Portland Harbor Hotel Addition

MEMORANDUM

Subject: Application ID: 2007-0089

Date: 9/7/2007

6 FIRST FLOOR PLAN  
 SCALE: 1/8" = 1'-0" 468 FORE ST. SQUARE FOOTAGE: 1702 SqFt

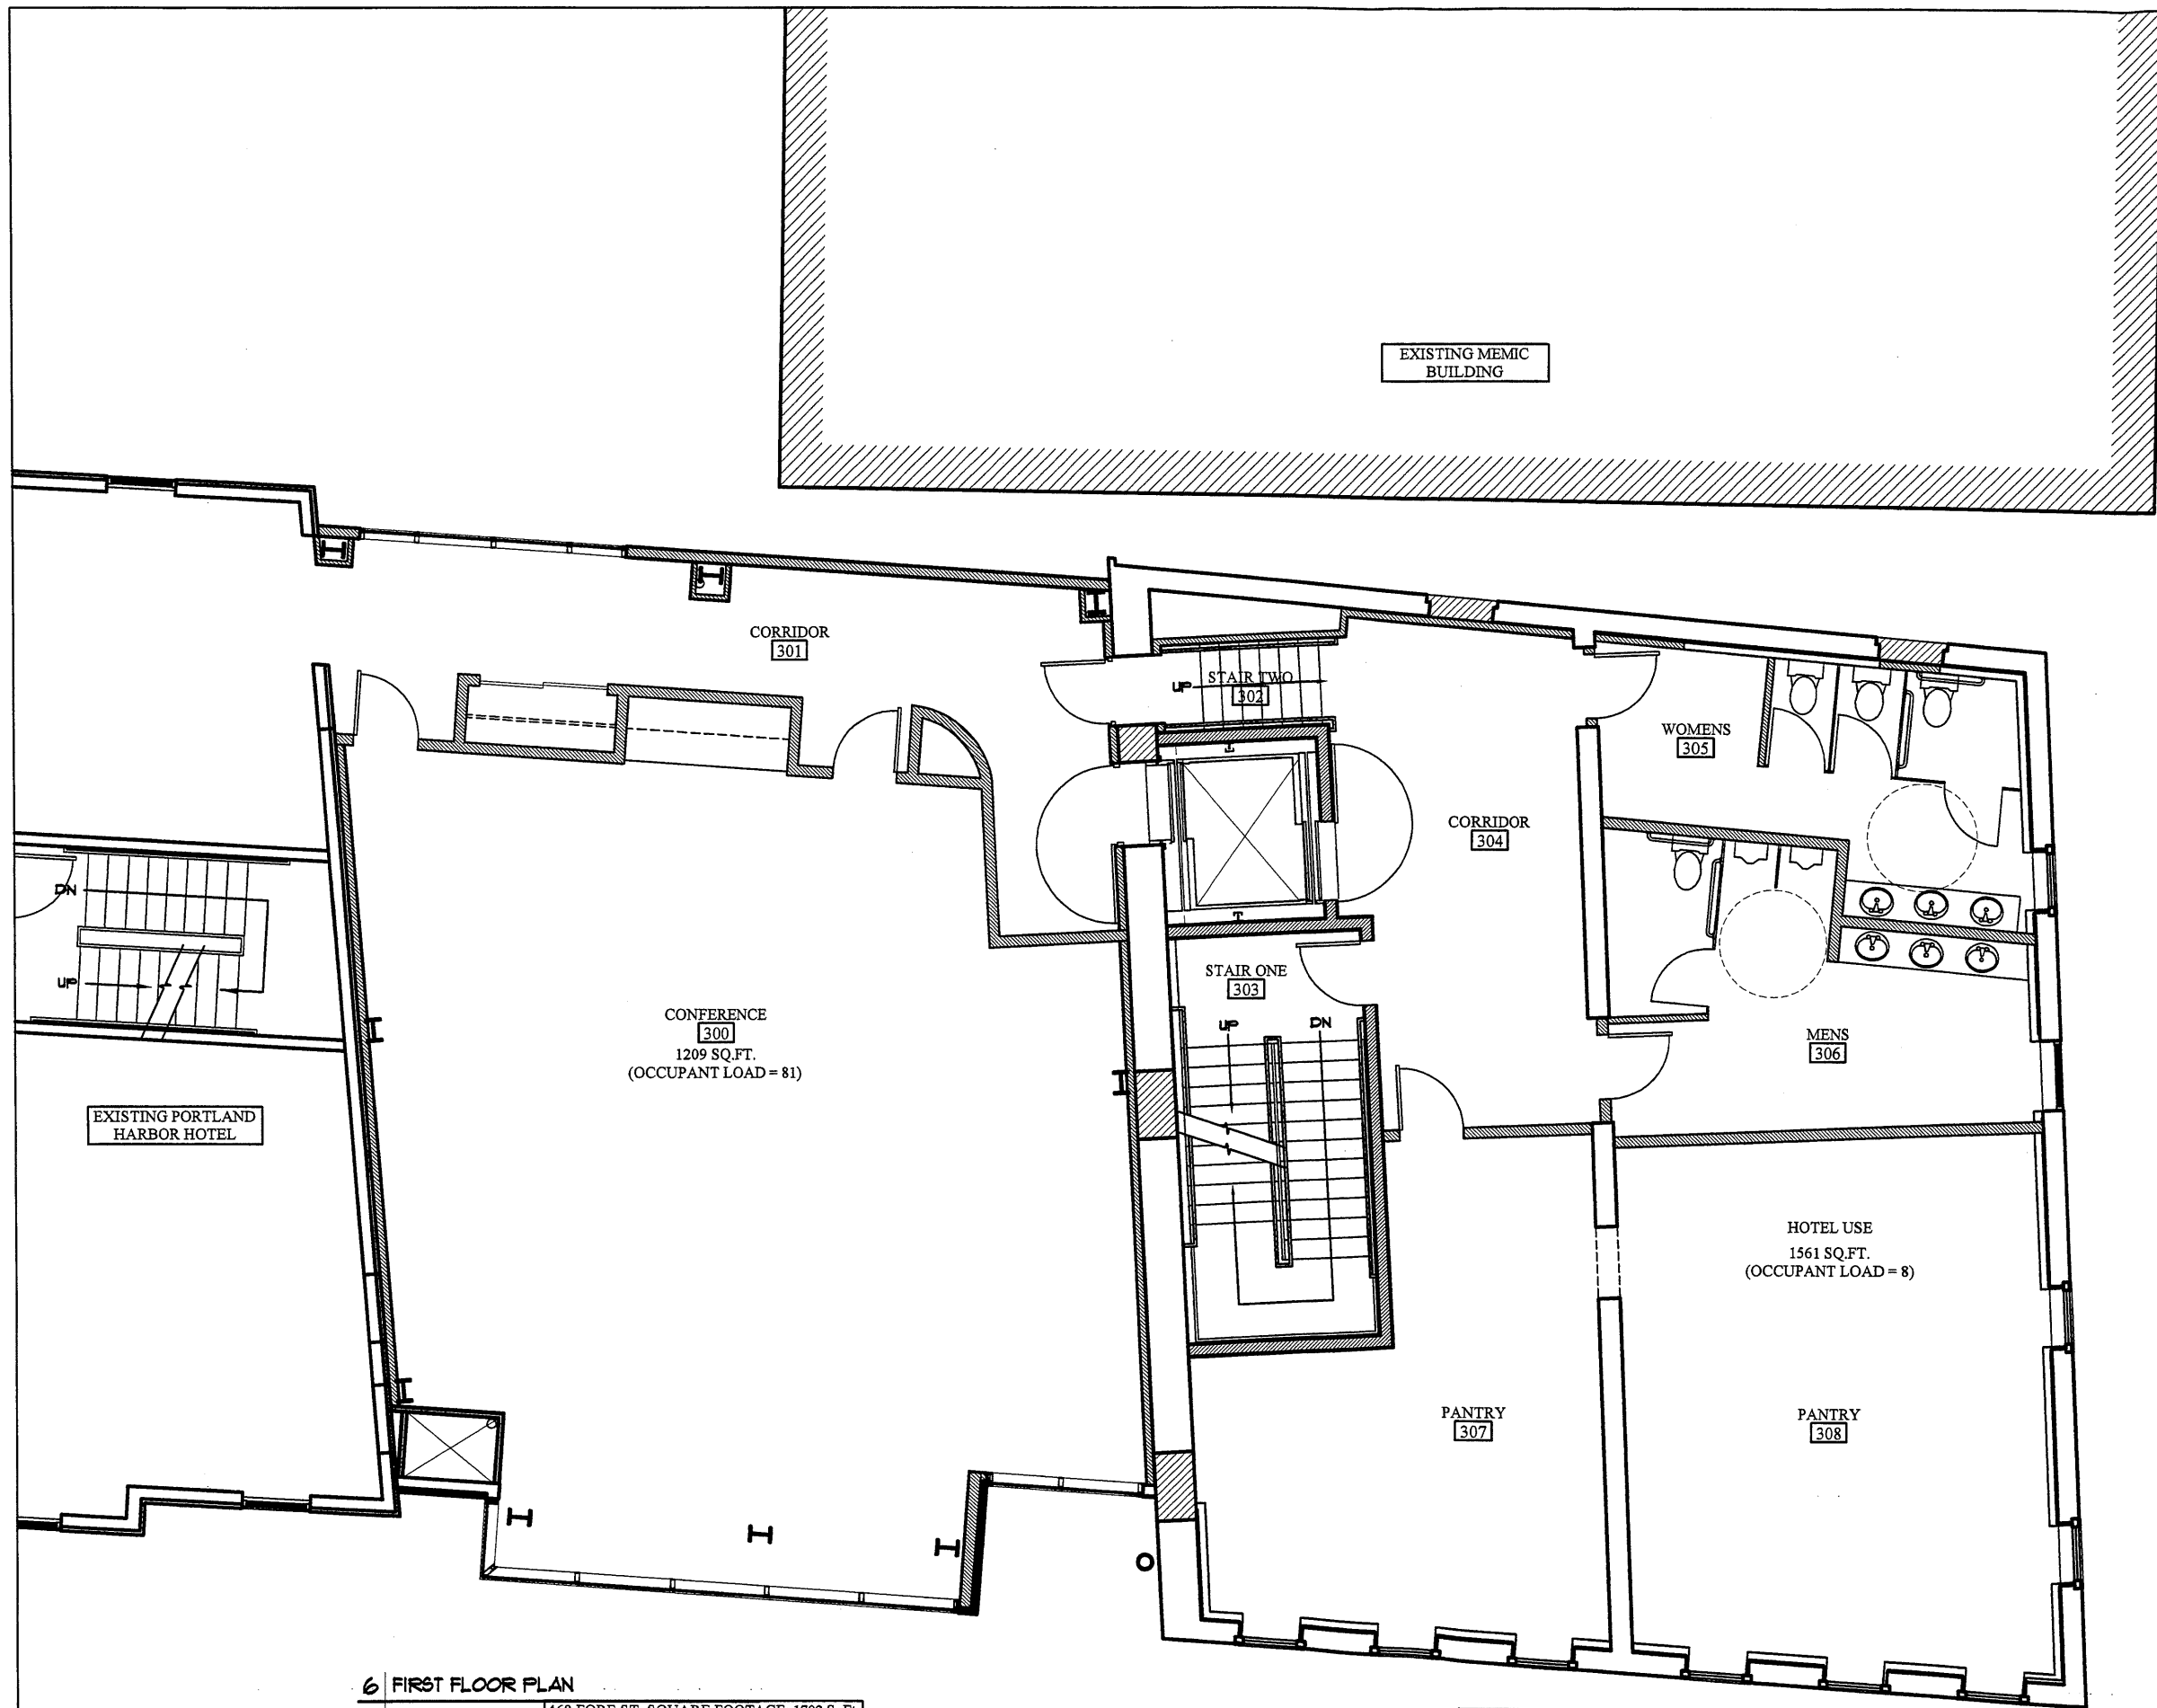
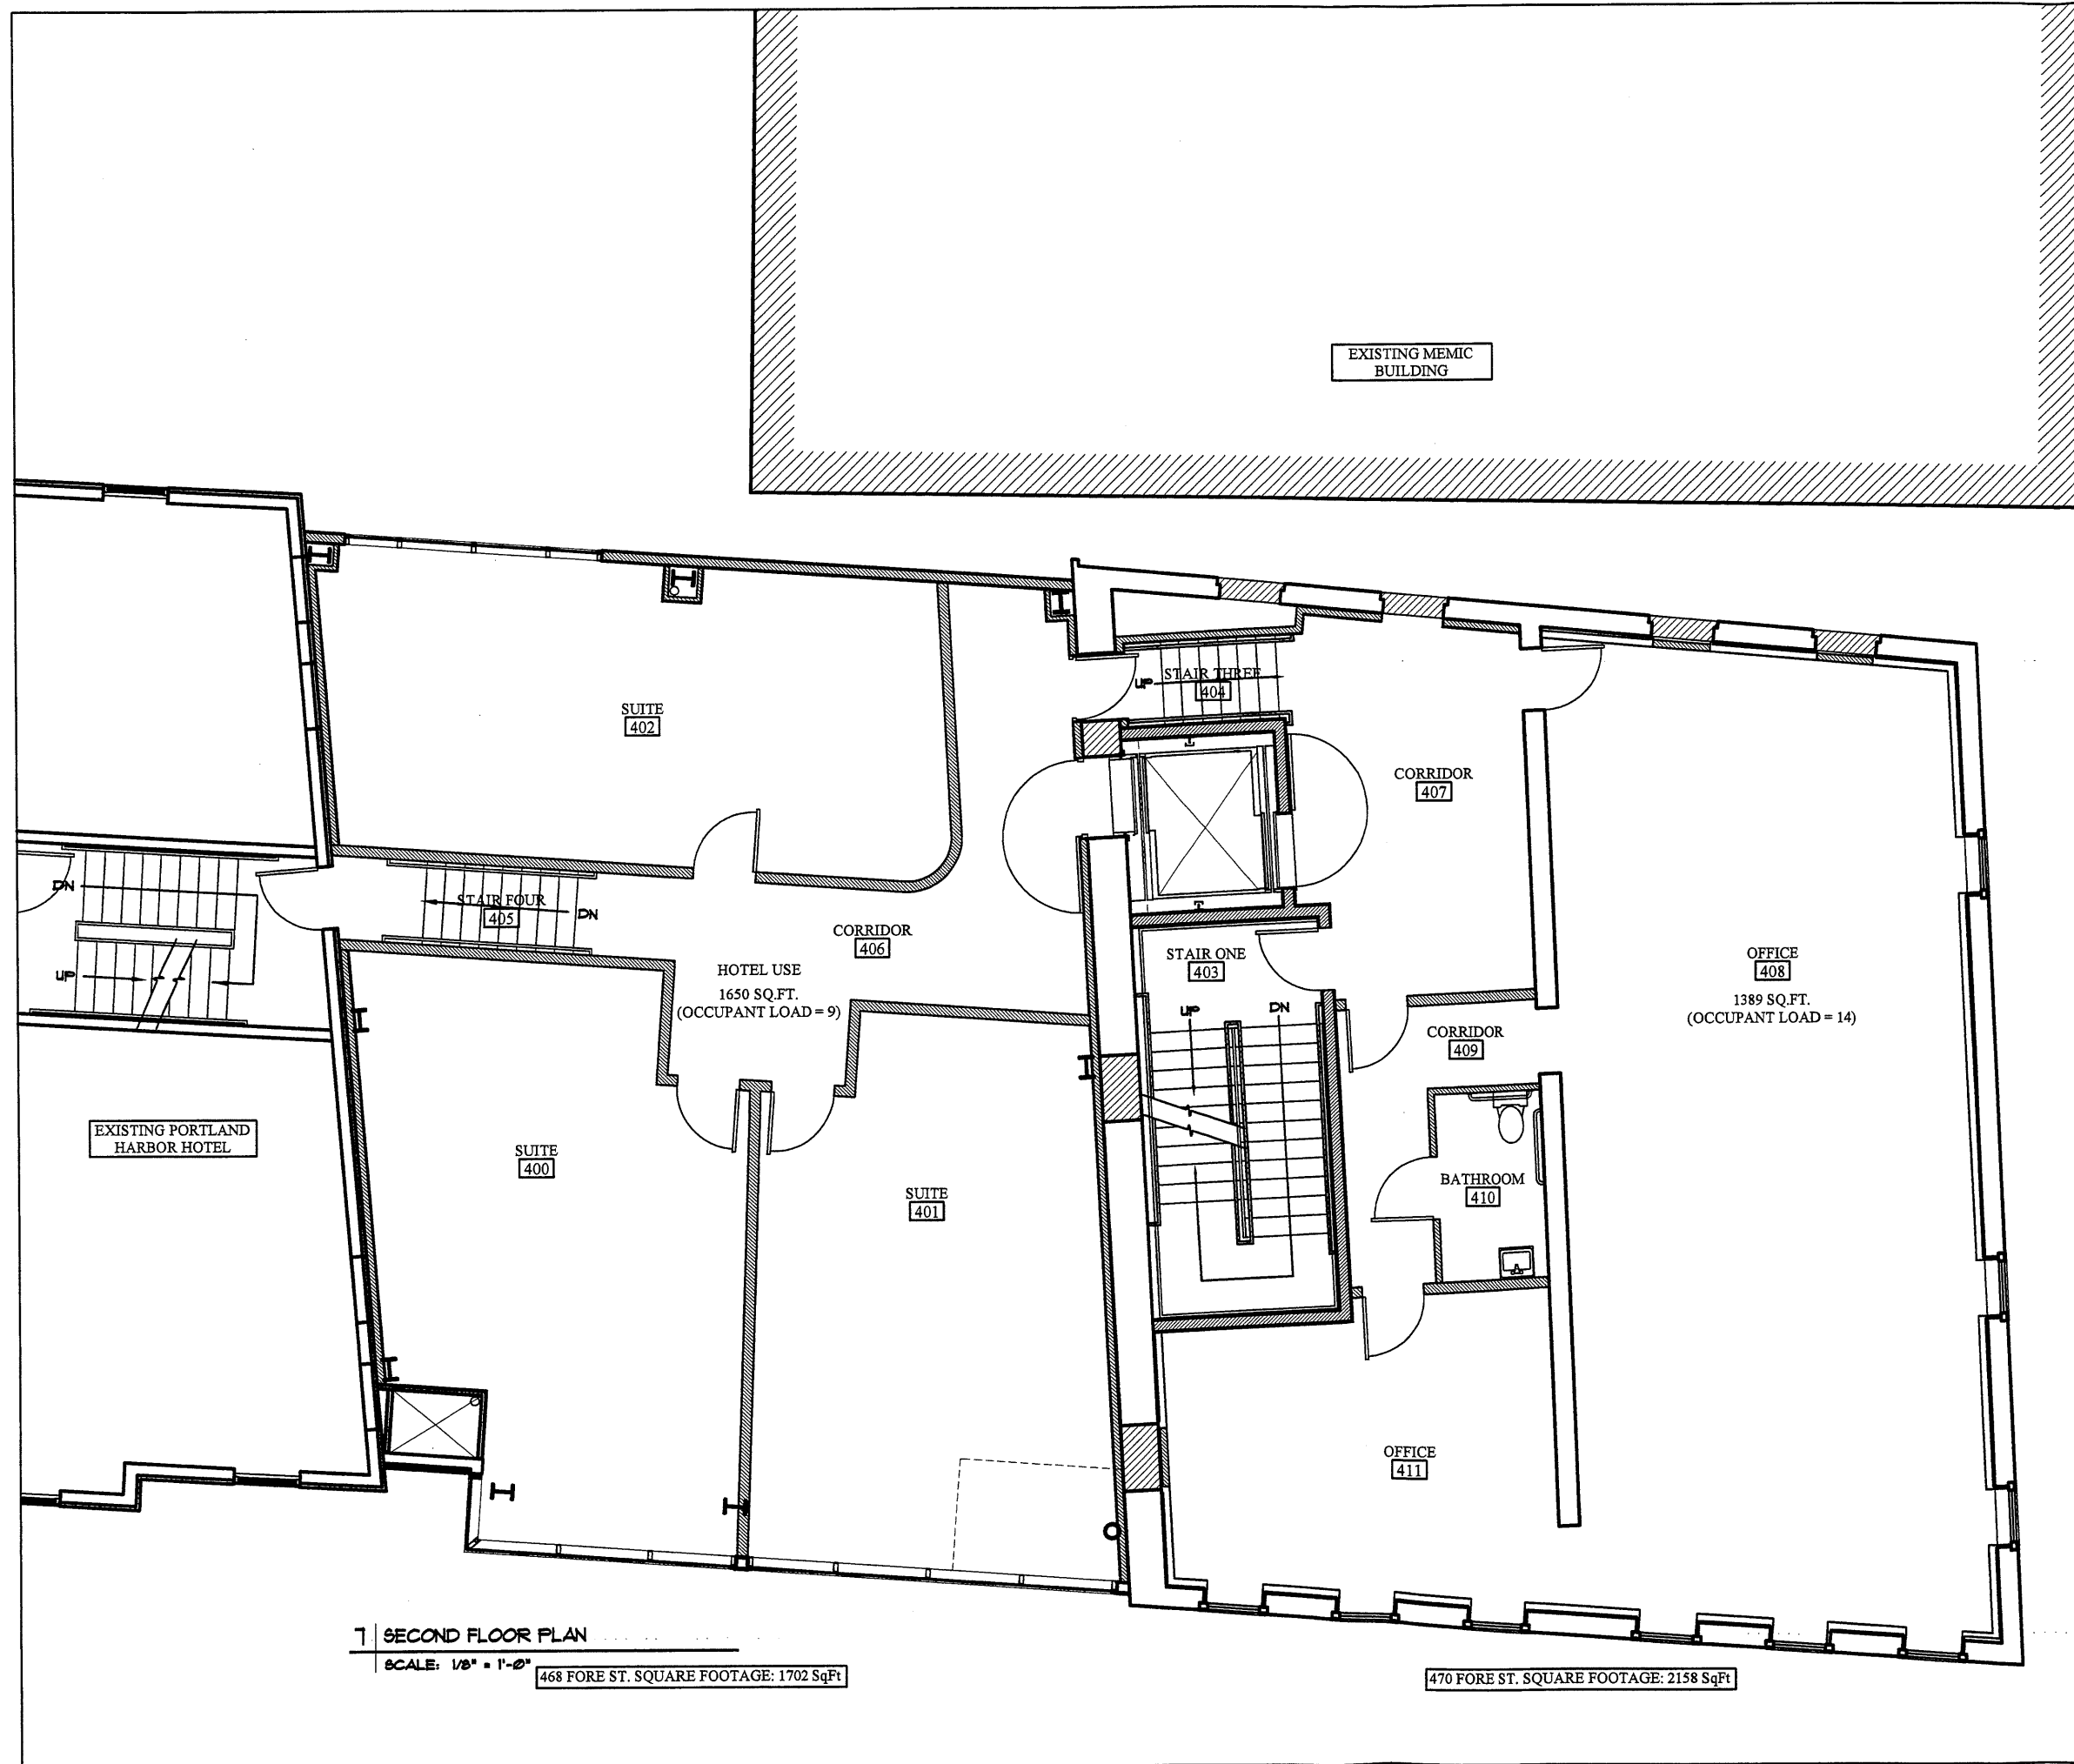
I have reviewed the floor plans received on August 29, 2007. My parking analysis of the new structure would require an additional 16 parking spaces. The parking study submitted on 5/31/2007 shows the existing parking capacity for the 16 addition parking spaces.

I have reviewed the basic submittal. I have noted that there are no floor plans to help determine uses and parking requirements. I do not agree with the methodology used to create the submitted parking analysis. The old Akari building was determined to be all retail in its past use. It was only partial retail with personal services throughout the upper floors. The wrong numbers from the parking section of the ordinance were used in this analysis. This being said, I agree with the bottom line that there is apparently a parking surplus that the proposed structure on site can use. I believe that the parking requirements are being met with this proposal. Only the new structure generates parking requirements. The change of use of the existing Akari building does not need to meet the parking requirements based upon the B-3 zone parking allowances.

I would like to see floor plans of the new structure and for the rehabbed Akari building to quantify the number of hotel rooms in total proposed.
